CITY OF MERCER ISLAND
Community Planning & Development

Ref: Intake Screen 2006-158
Site Address: 8802 SE 37th St Mercer Island

REVIEWERS COMMENT RESPONSE LETTER

SHEET NUMBER
P1
Revision # 10

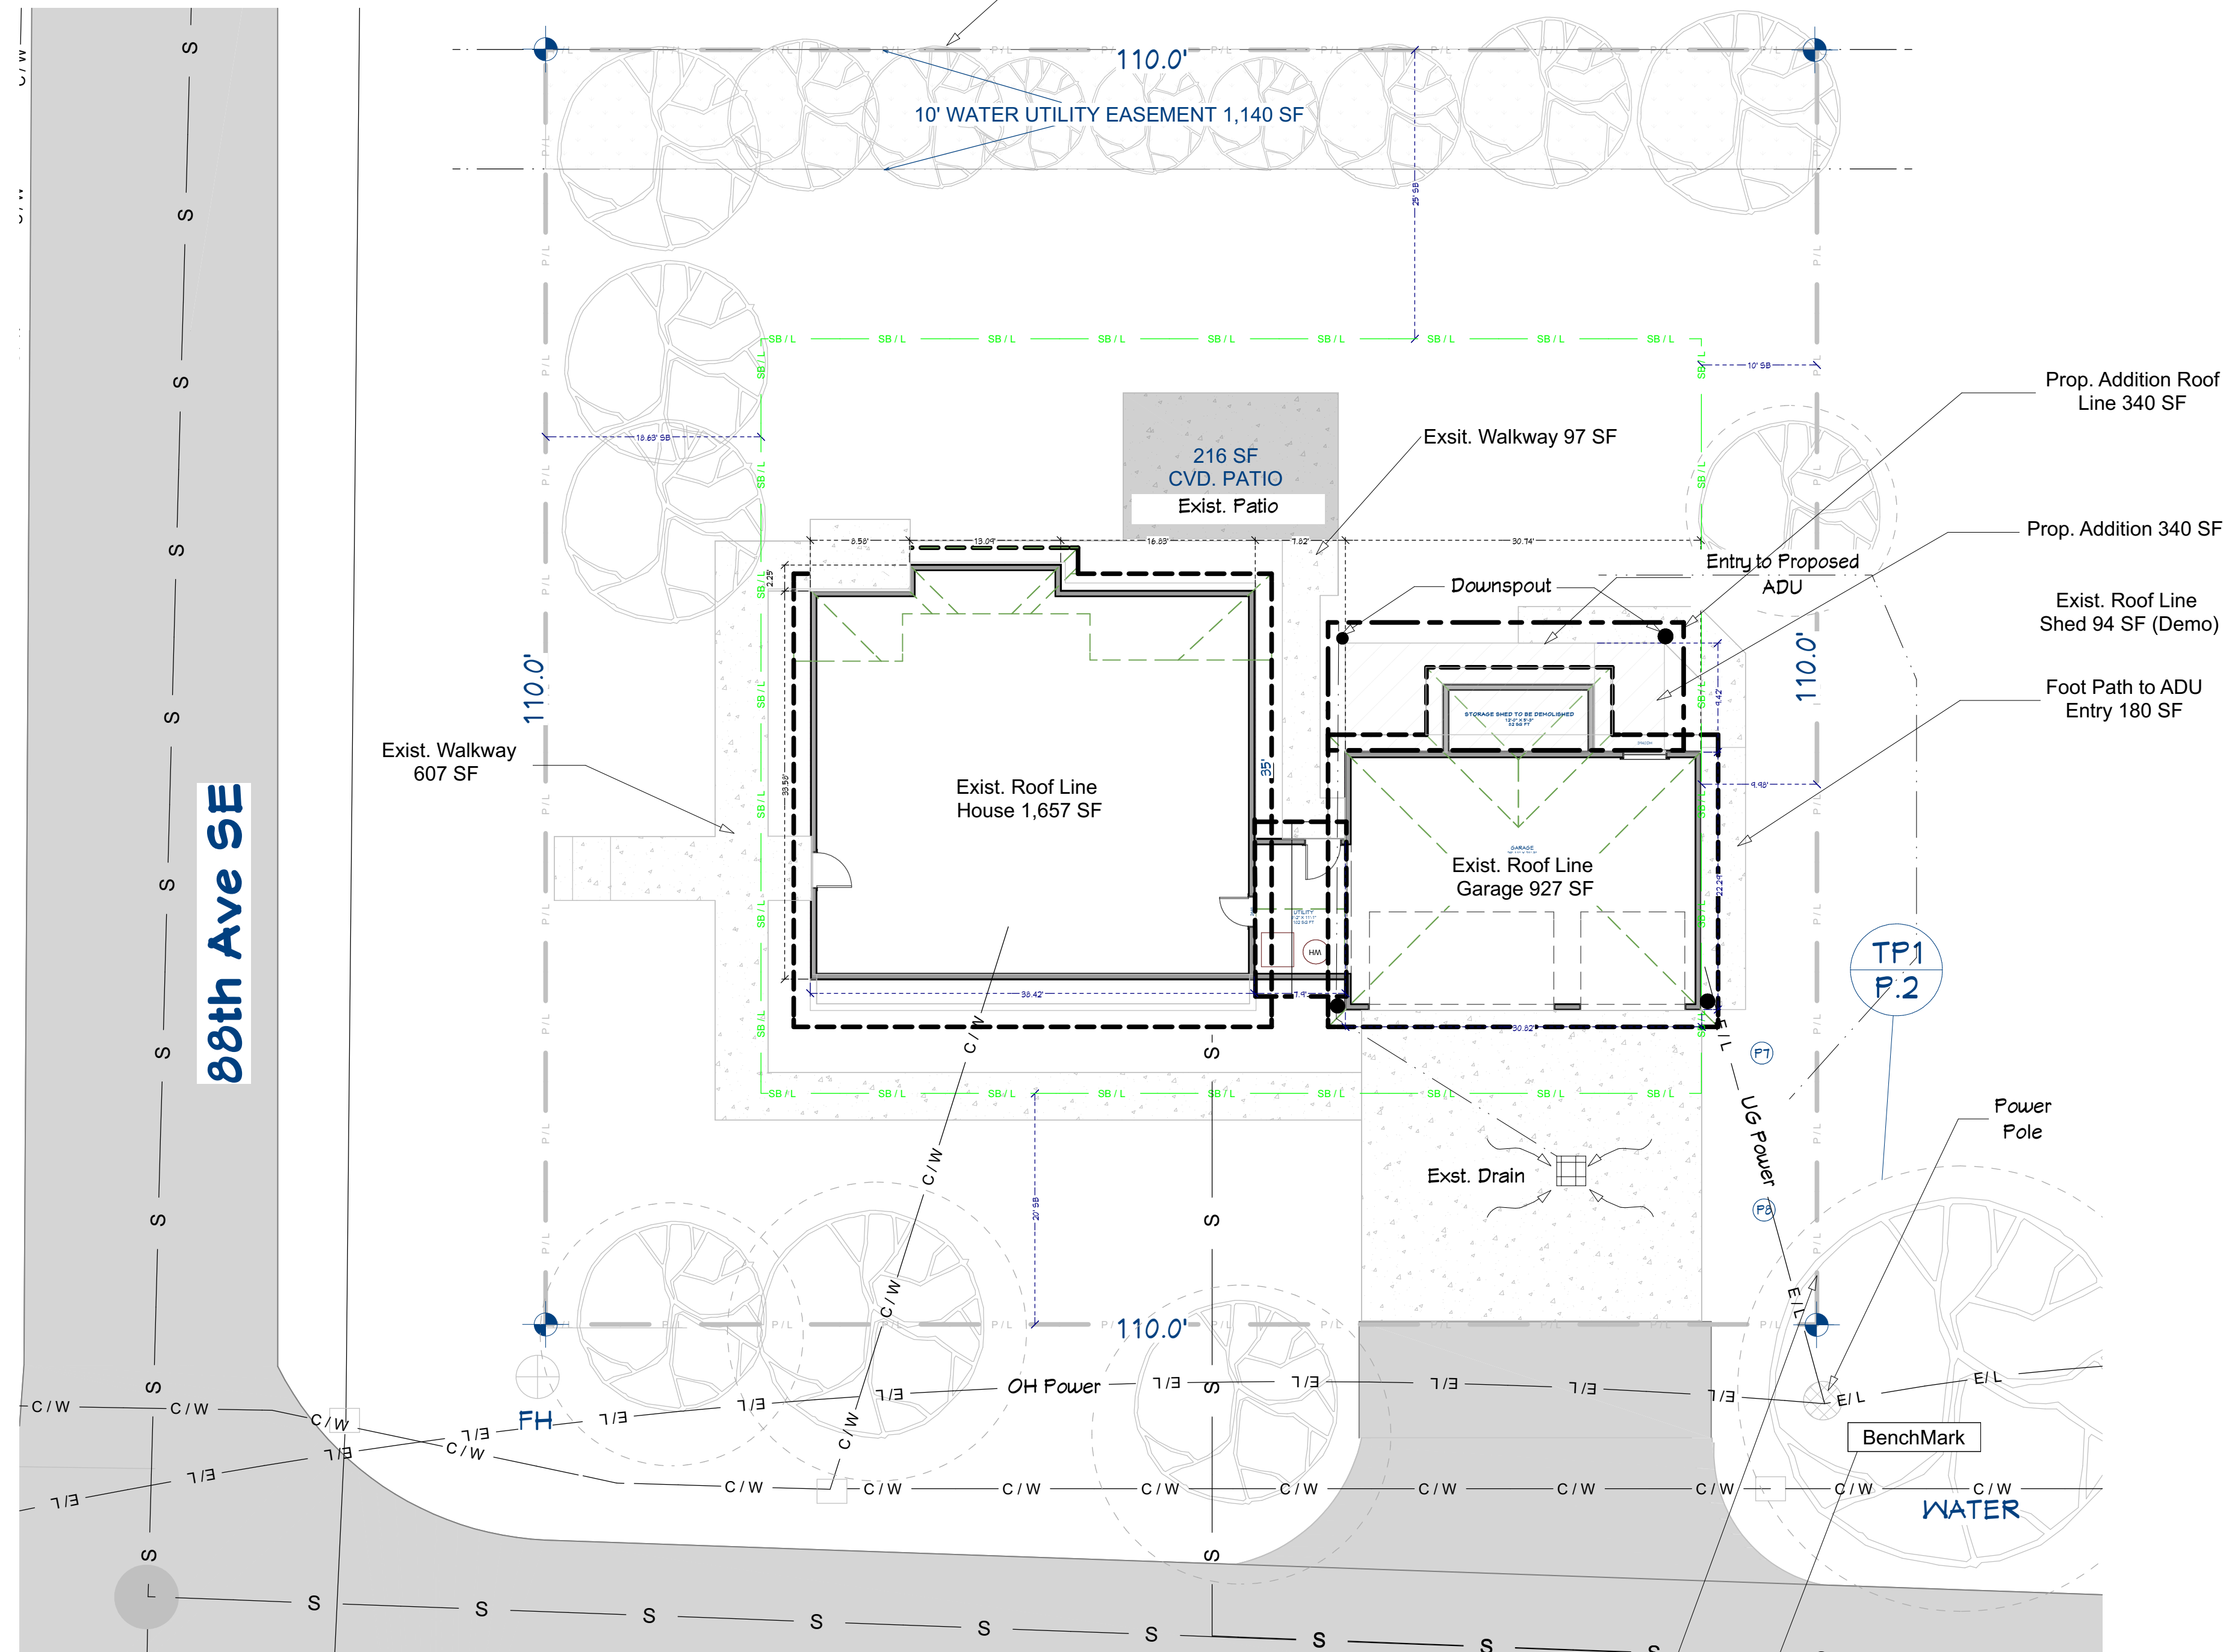
Land Use Planning; Andrew Leon.

Revised Sheet P1. New Lot Coverage Calculations.
Complete ADU Application packet Included in submittal documents

P2

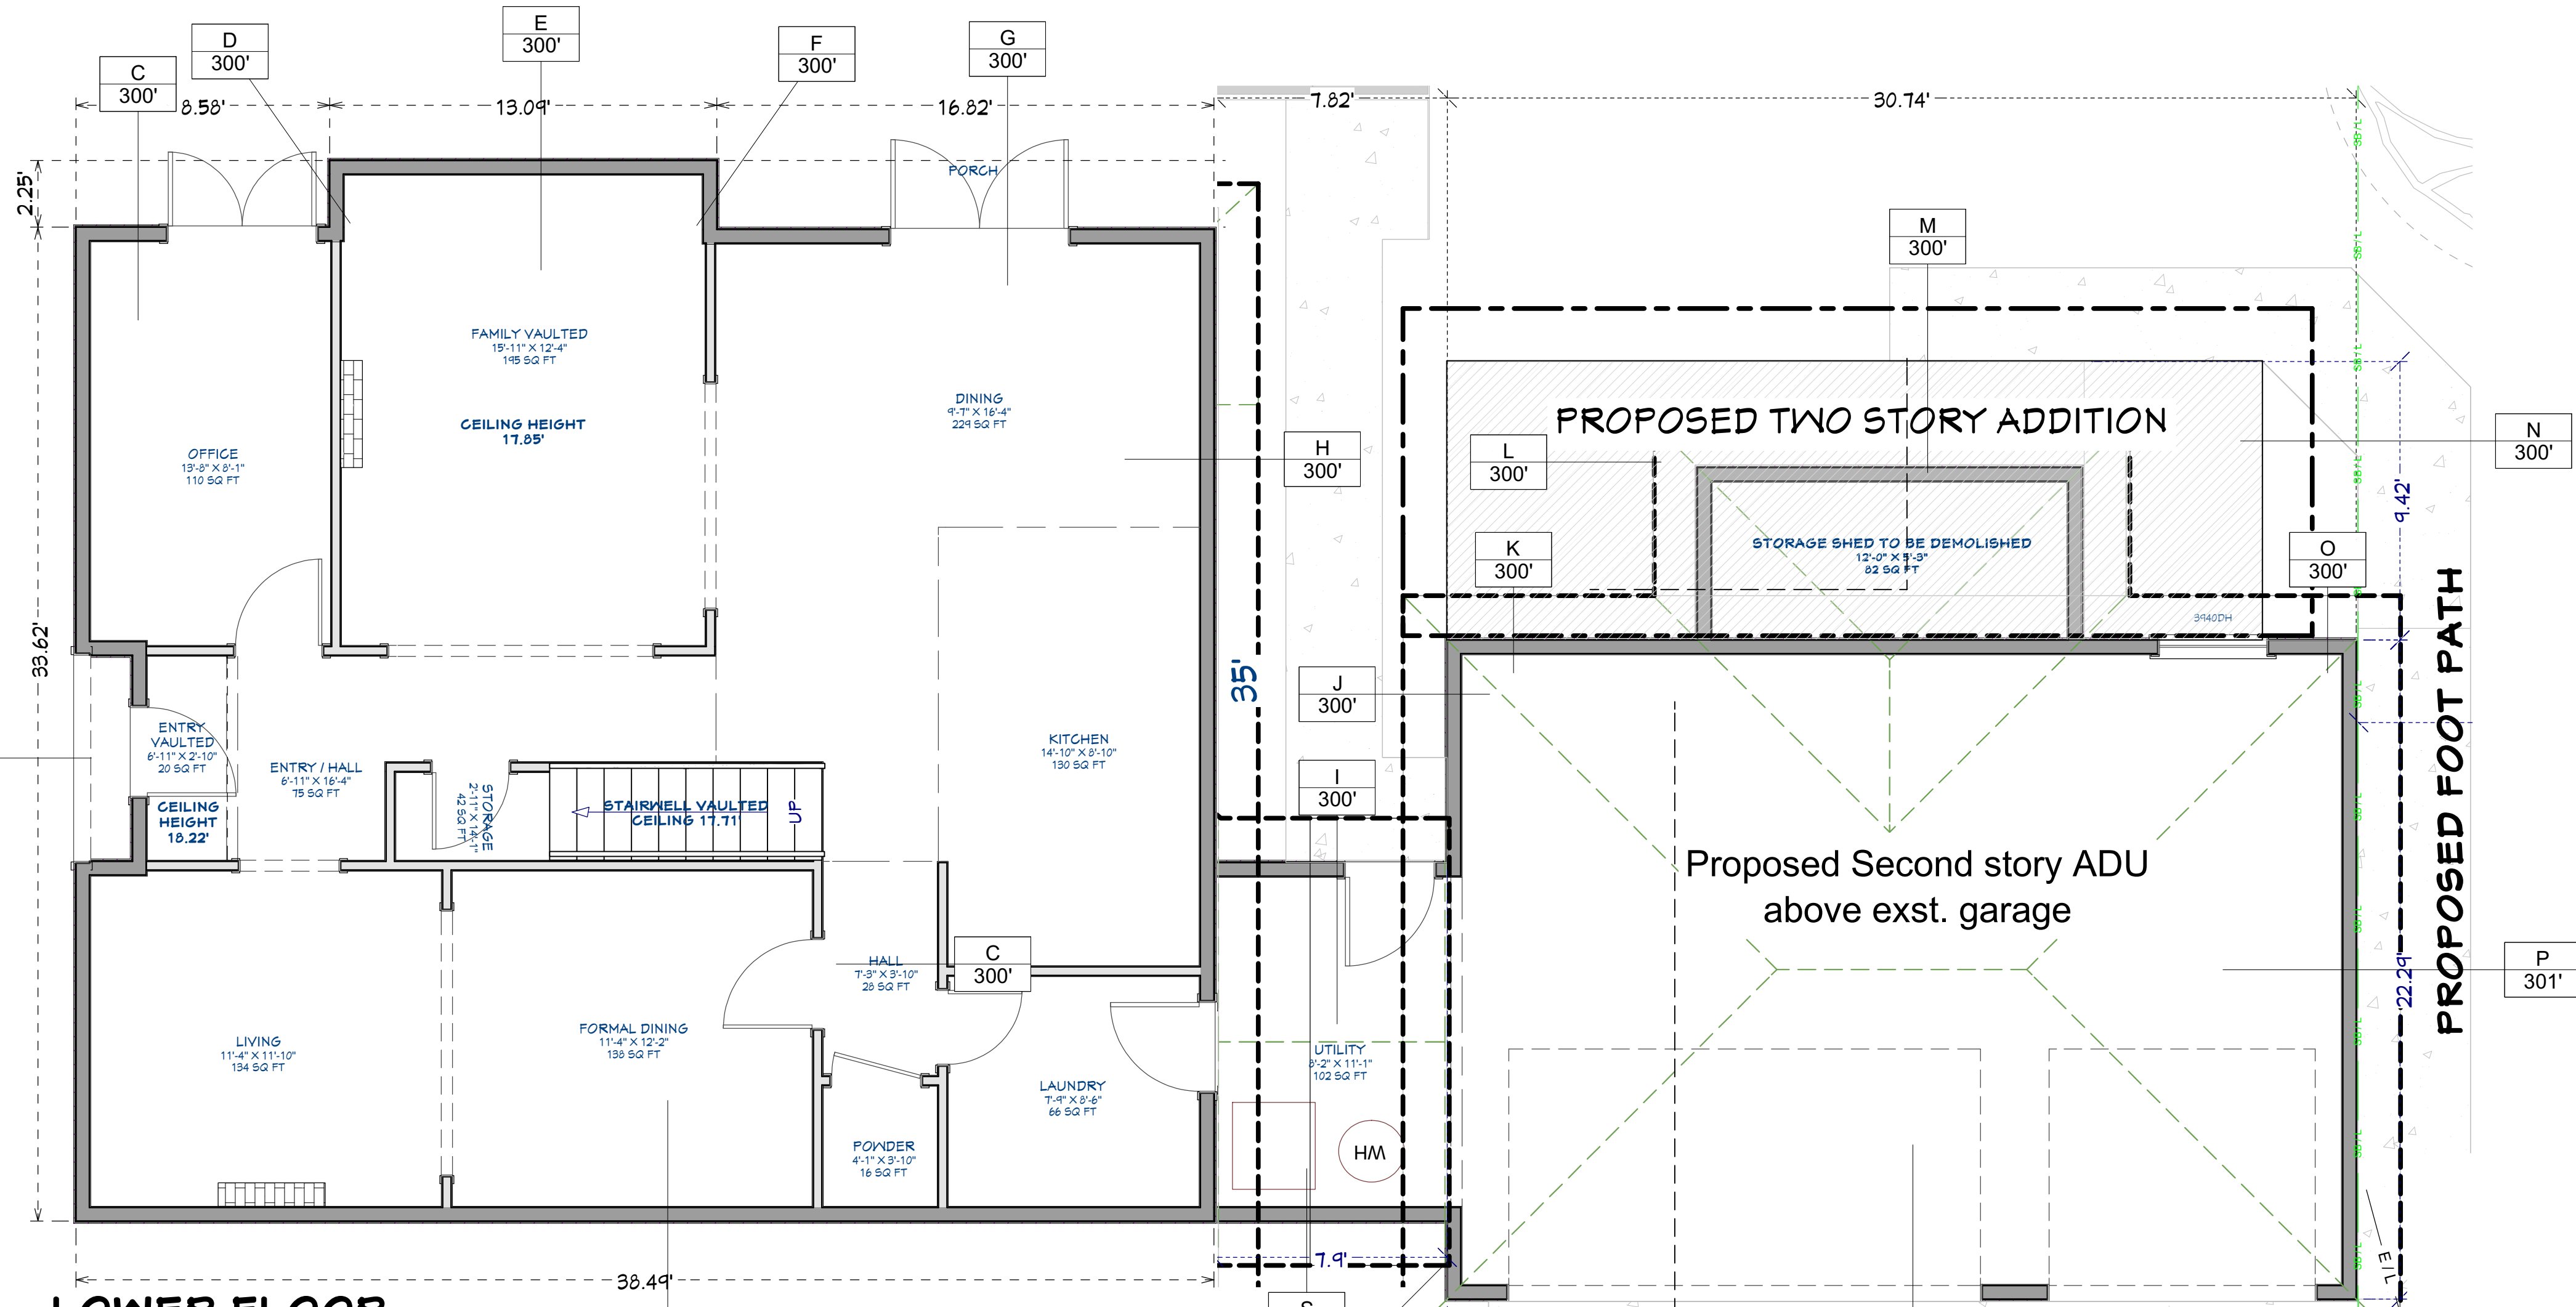
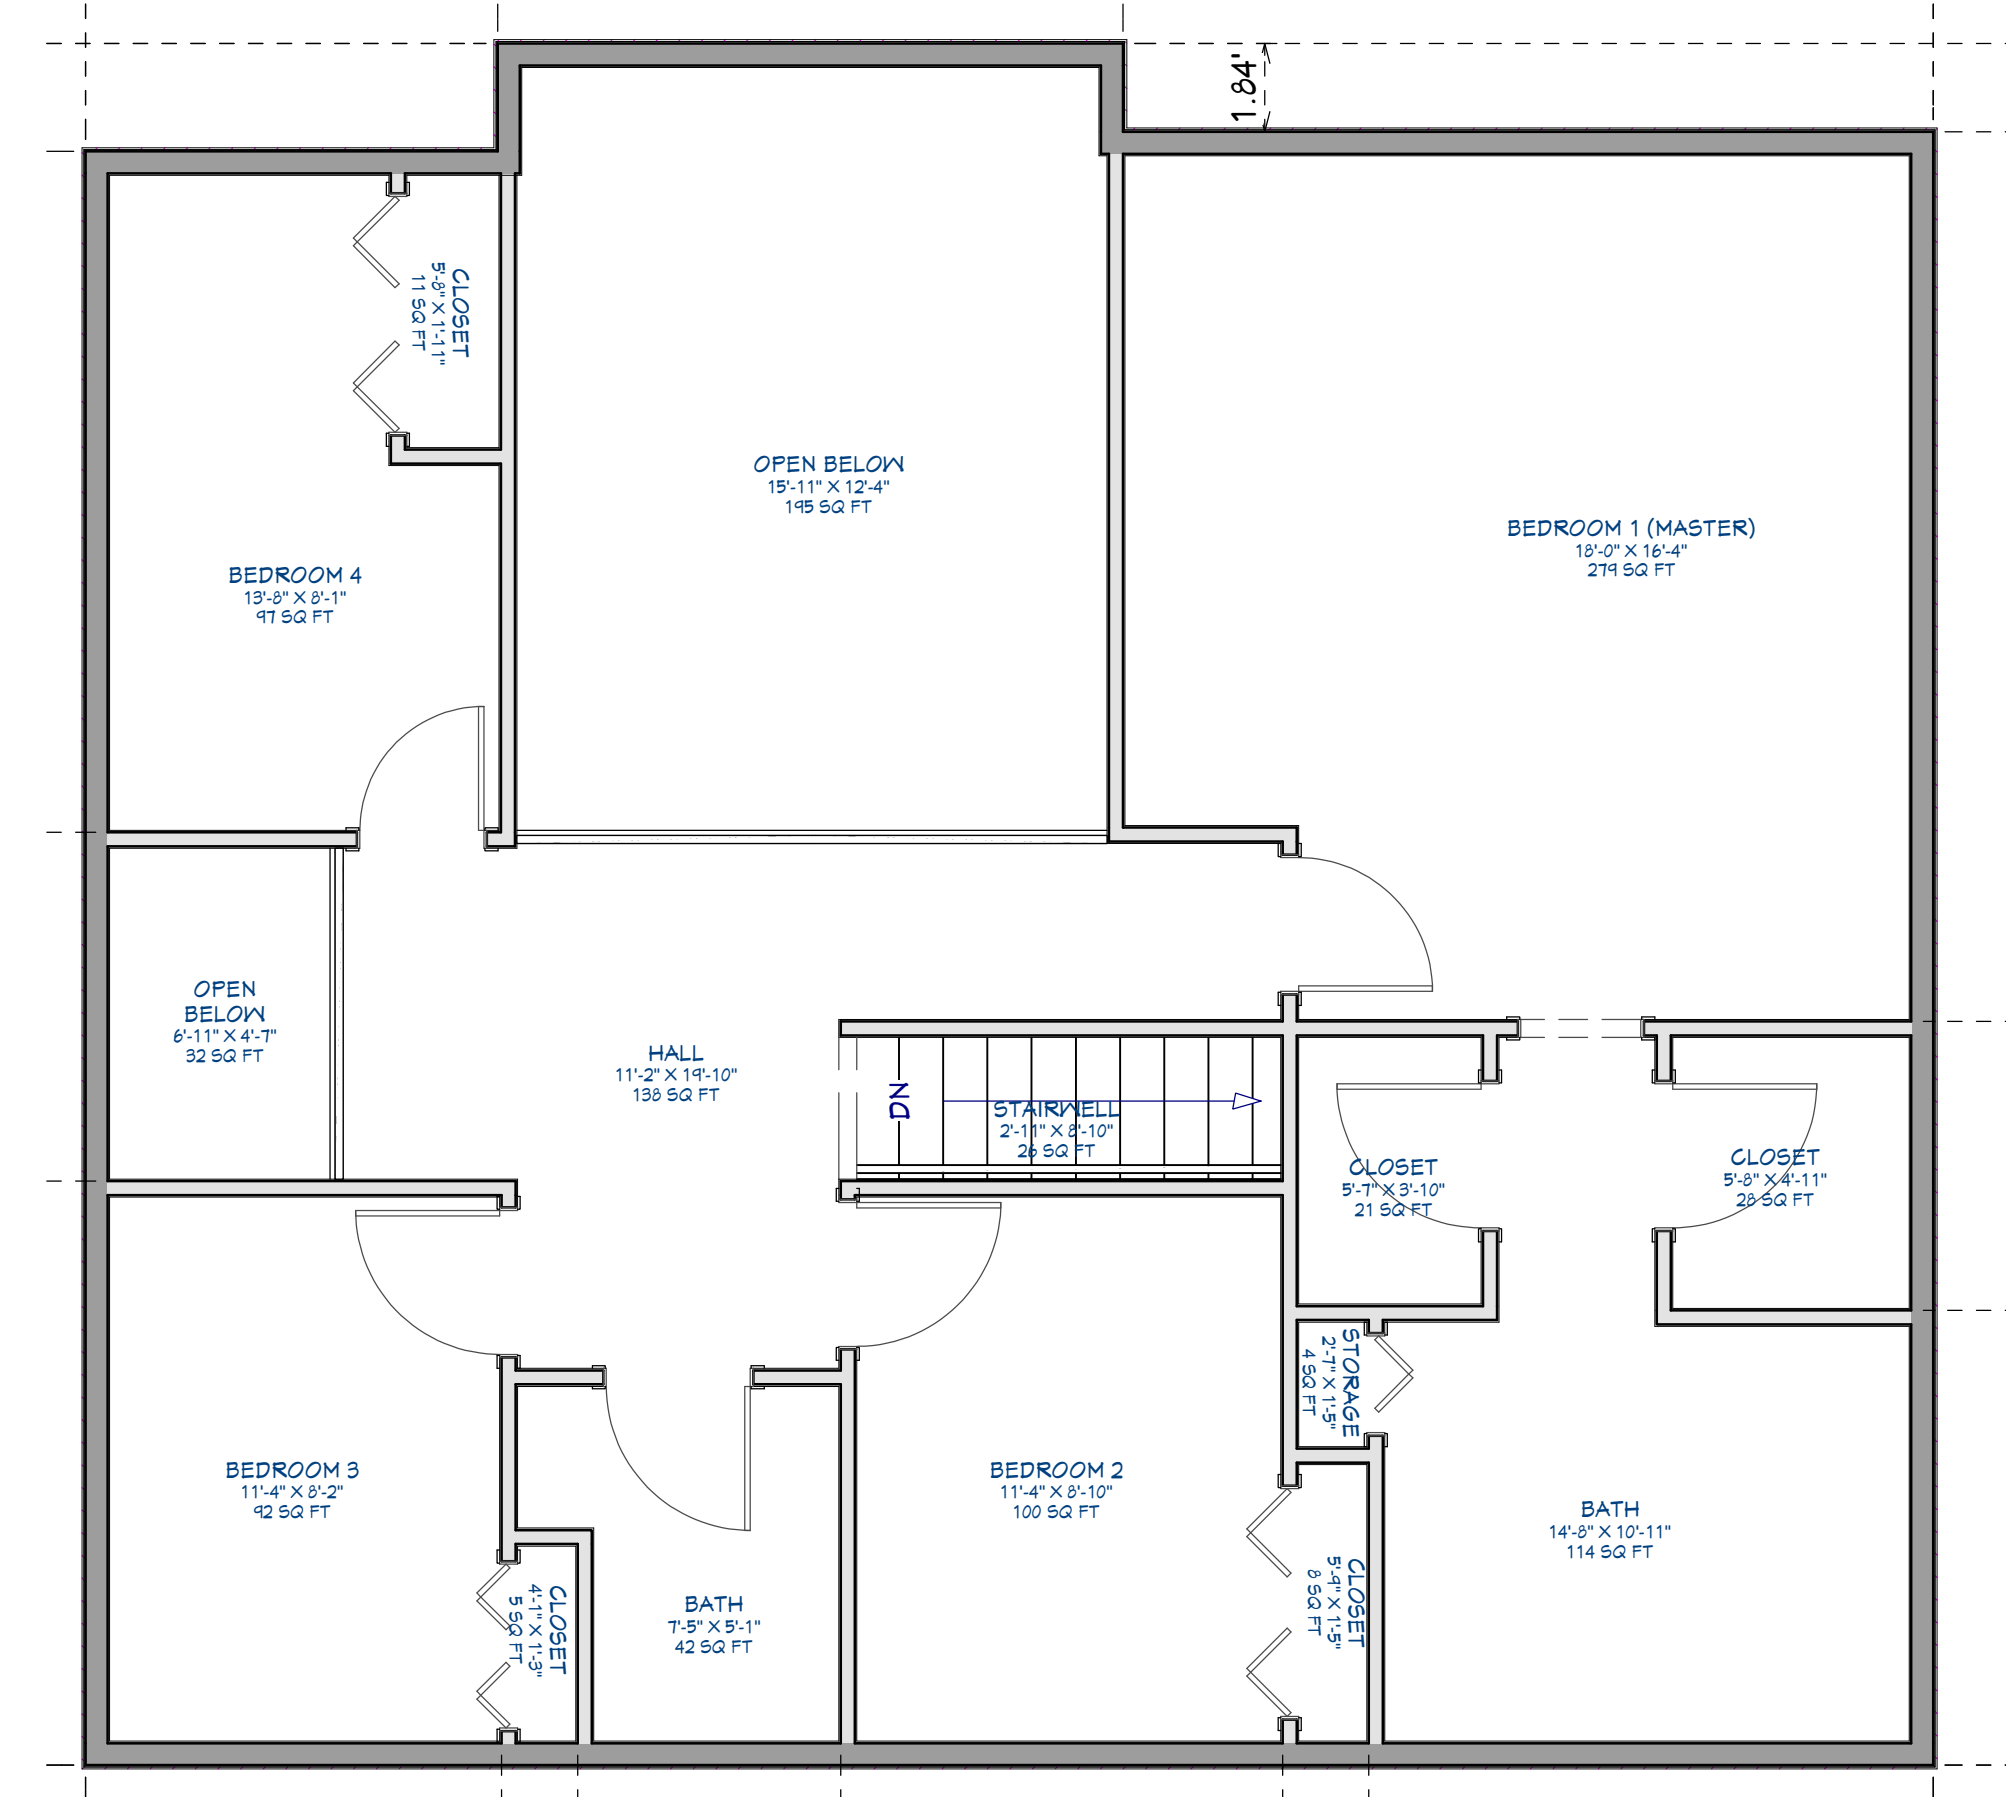
Building Division; Garth Reech.

Compliance path used is 2018 IRC. The design considers $K_{zt}=1.6$ per Mercer Island Mapping. New supplemental sheet P.2 provides Braced Wall Calculations based on this consideration. Headers are also based on 2018 IRC Table R802.5.1(3) Sheet A9 .
GLB gravity calculations provide on sheet SP.2
